Please ask for: Ms Iqraa Malik
Email: iqraa.malik@terraquest.co.uk
Telephone: 01212341390
Our Ref: BR/160/20/HH
Your Ref:
Date: 20th July 2020

Application for Planning Permission for Works or Extension to a Dwelling

Development: Single Storey Rear Extension
Location: 212 London Road Bognor Regis PO21 1AX

PROPOSED GROUND FLOOR PLAN

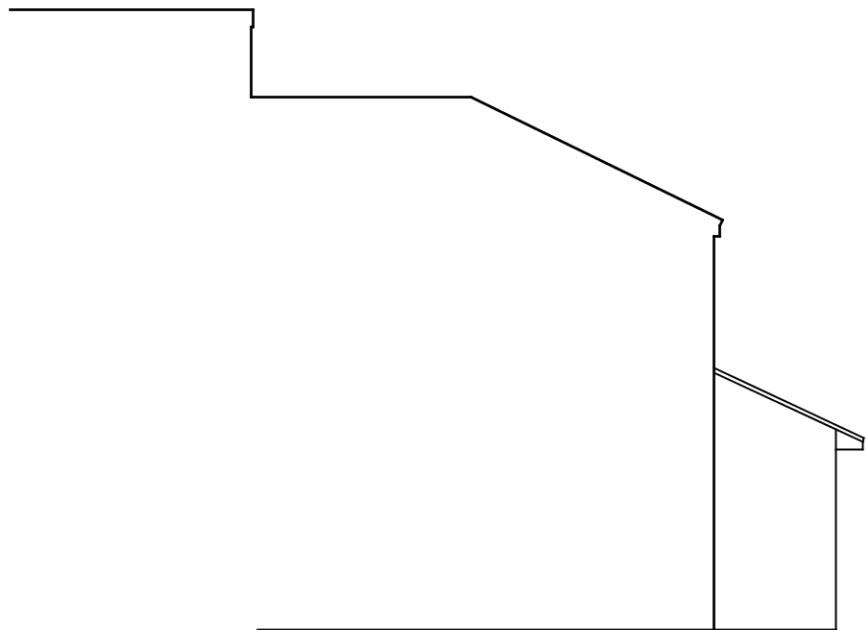
Please confirm the scale of the proposed plans submitted is 1:100, as the scale bar you have submitted at 1:50 does not measure to scale.

The building line on your proposed north elevation is inconsistent with your proposed ground floor plan. Please amend.
